Mathew Banks  
83 Maltravers Street  
Arundel  
West Sussex

Development Control  
Arun District Council  
The Arun Civic Centre  
Maltravers Road  
Littlehampton  
West Sussex  
BN17 5LF

Planning application : AB/5/18/PL  
Proposed first floor extension and change of use

Plans and Elevations
Proposed

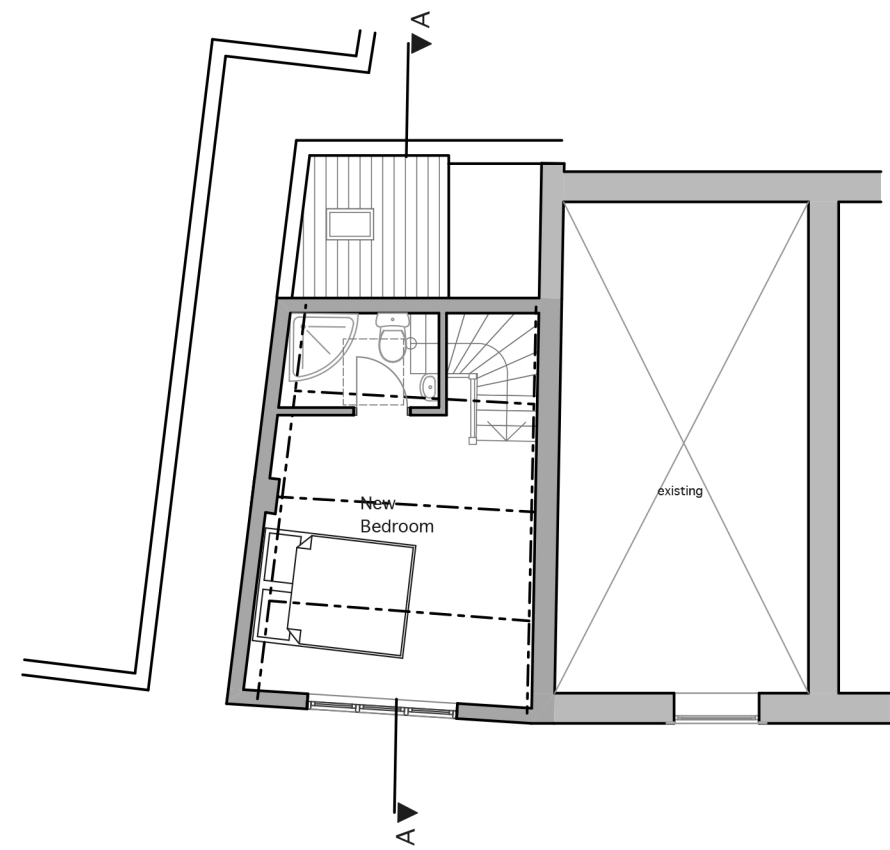
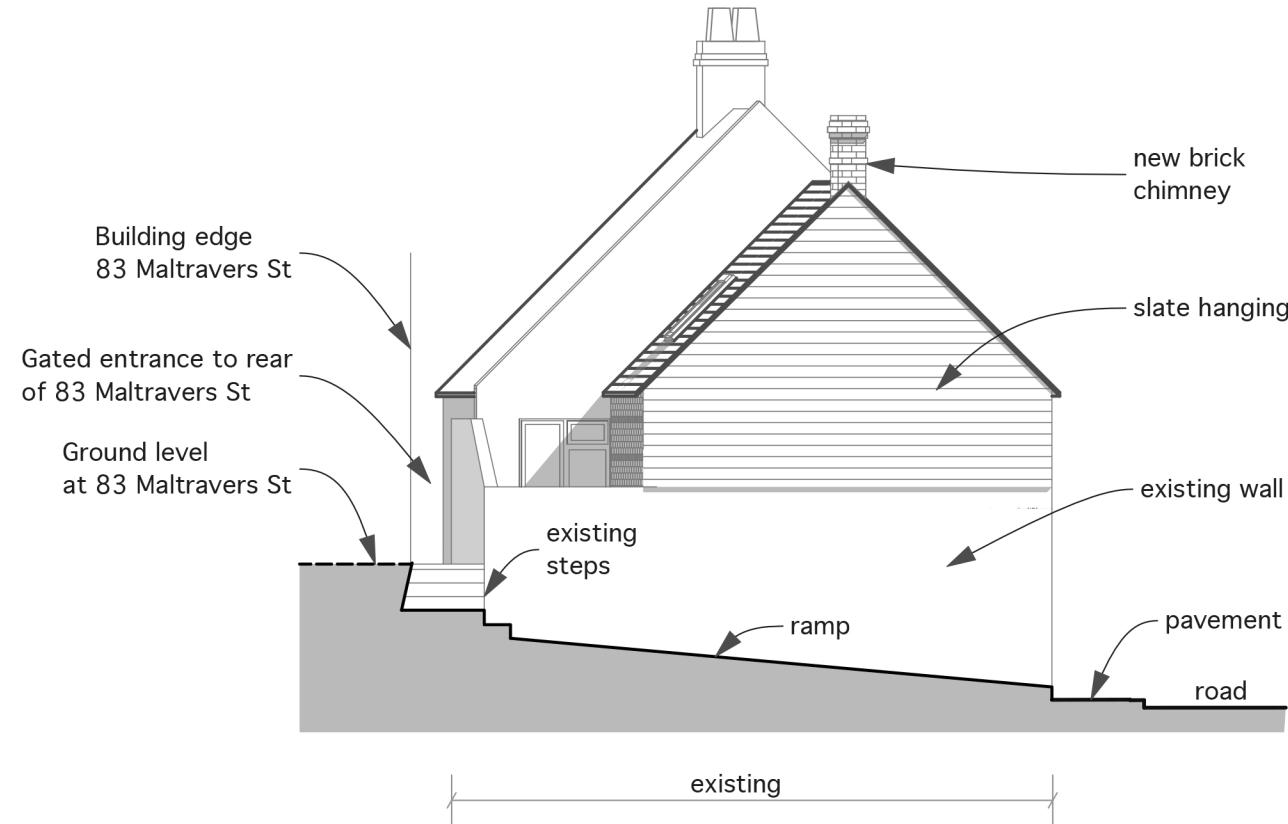
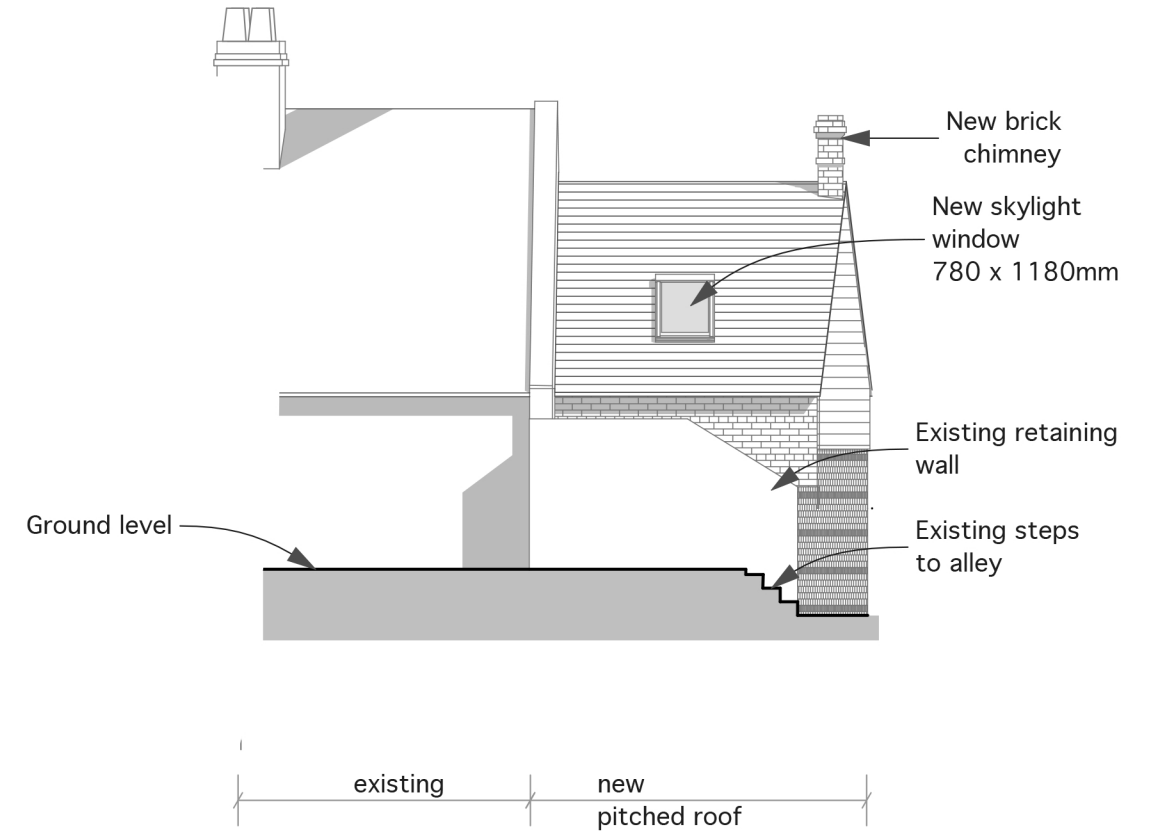
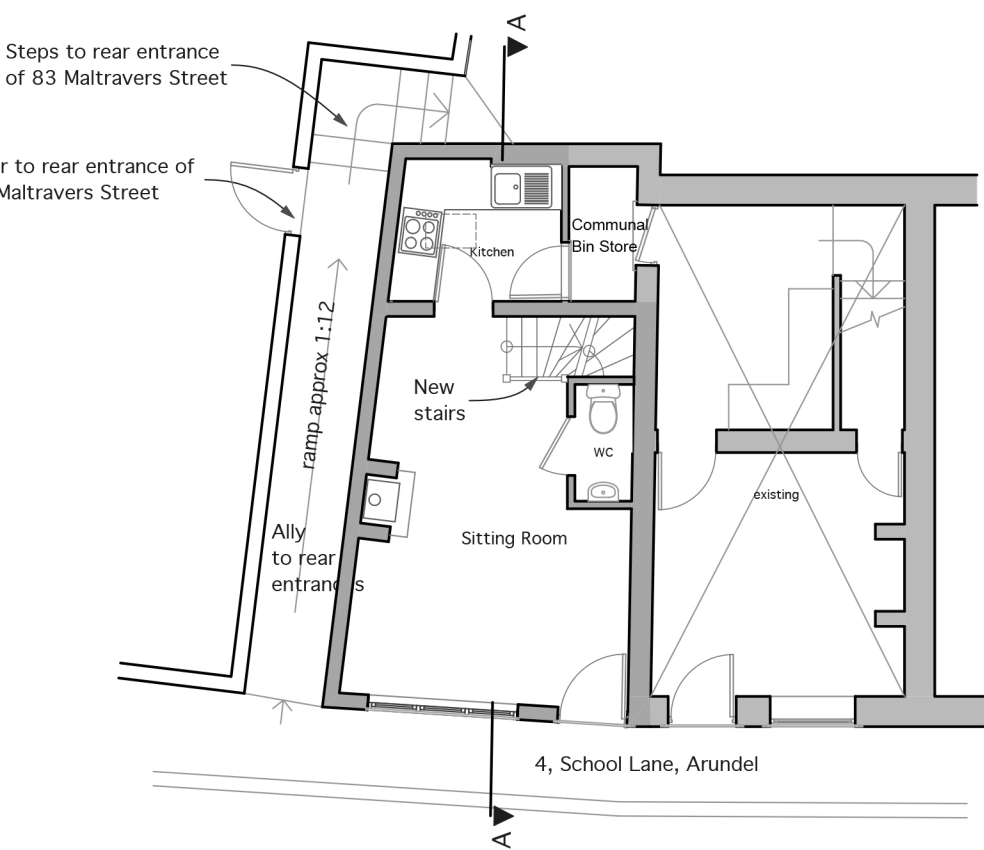
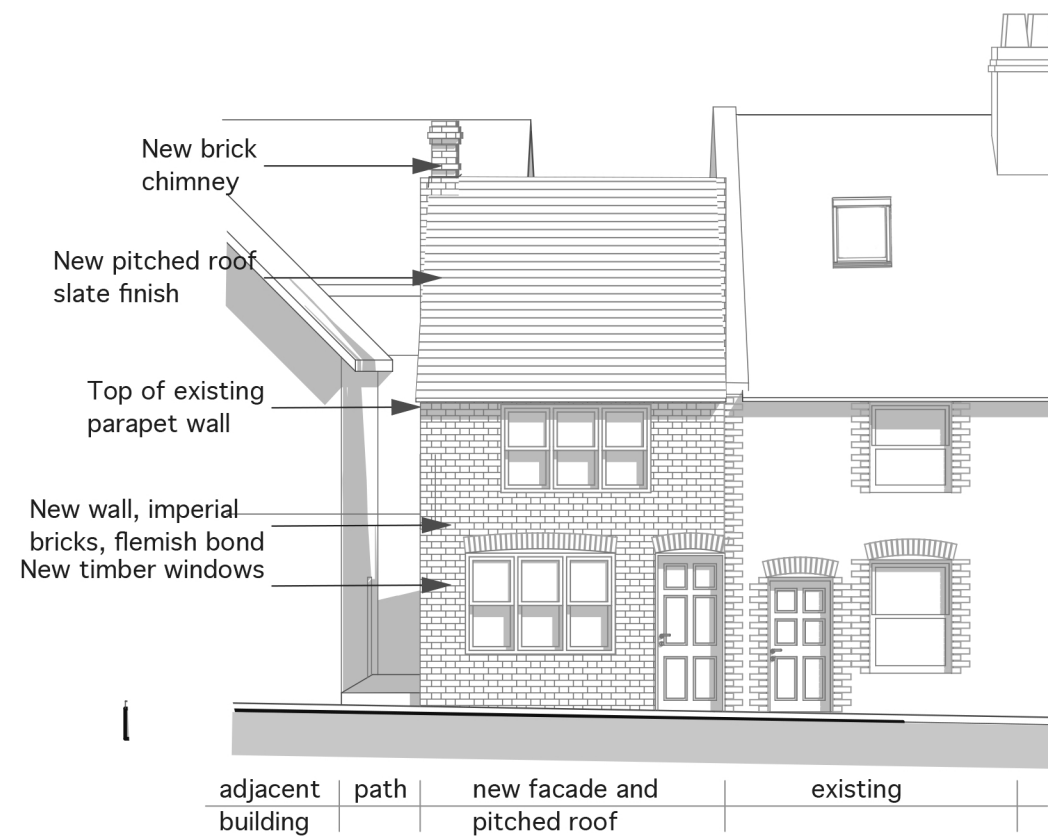
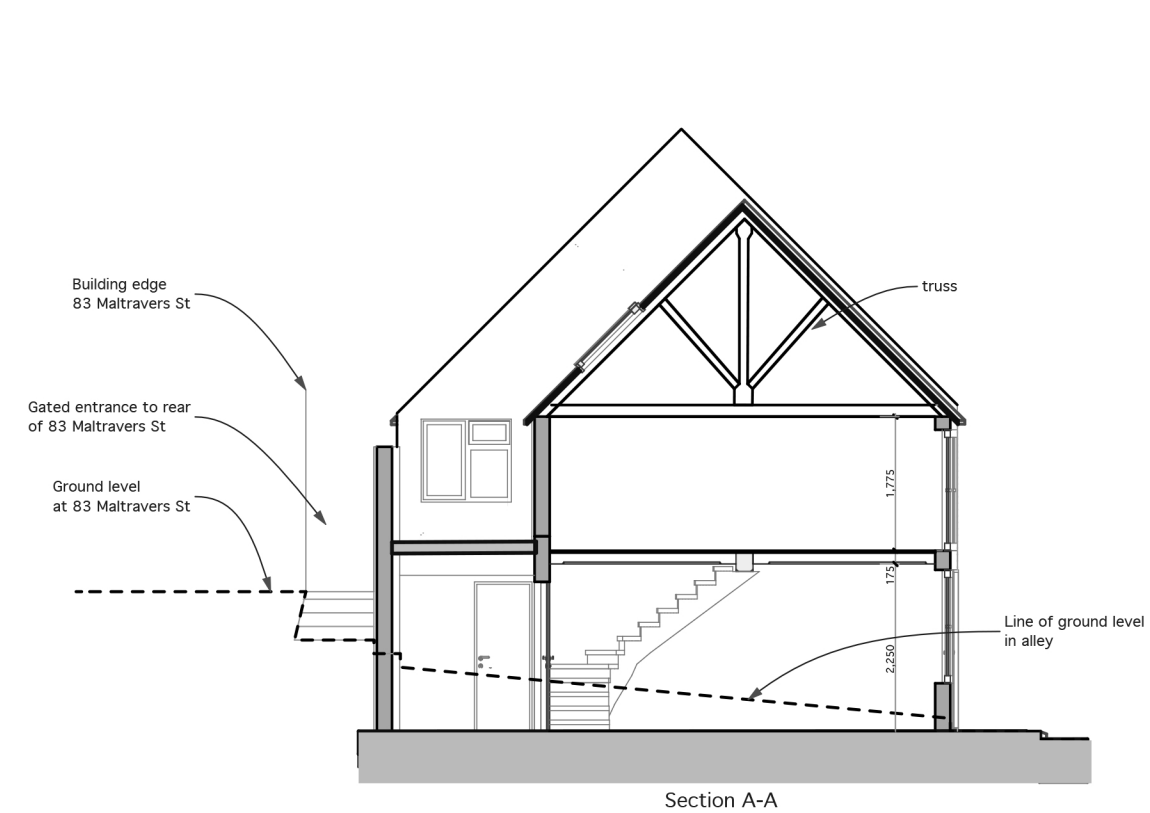
I also feel that if the extension is allowed it will have a negative effect on the amount of light coming in, not only into my garden, but into those of my neighbours, especially during evenings. Although being open to the sun for the majority of the day, at the moment we still get the evening sun and light, as do my neighbours, allowing this application would take this benefit away from myself and those that live next door.

If permission was granted it would take away a certain amount of privacy afforded to me at present. I don't want to feel that I'm being hemmed in, that the "walls are closing in on me". If permission is granted, I ask that any windows that overlook my property be obscured with glass, so as still to give me some privacy, and that if those windows are to be changed in any way, that permission must be granted beforehand.
